Our Ref: P/100/19/HH
Your Ref:

Town & Country Planning Act 1990 (as amended)
Town & Country Planning (Development Management Procedure) (England) Order 2015
Application for Planning Permission for Works or Extension to a Dwelling

Development Single storey side extension and conversion of roofspace to habitable use to include a side dormer and conversion of roof from hip to gable end, and alterations to front bay windows

Location 9 Kings Drive Pagham

Proposed North Facing Elevation

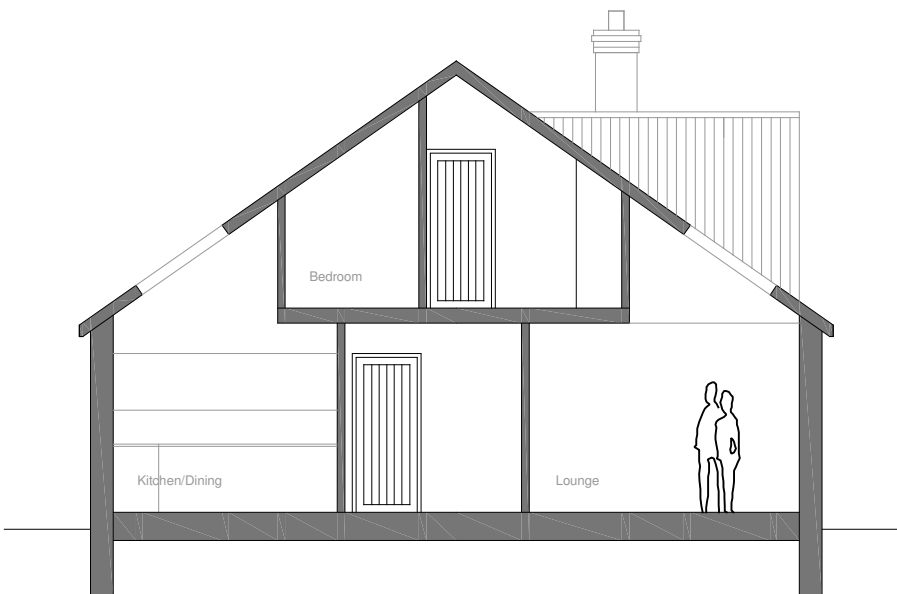
The width of one of the windows does not match between the proposed ground floor plan and north facing elevation. Please review and amend accordingly.
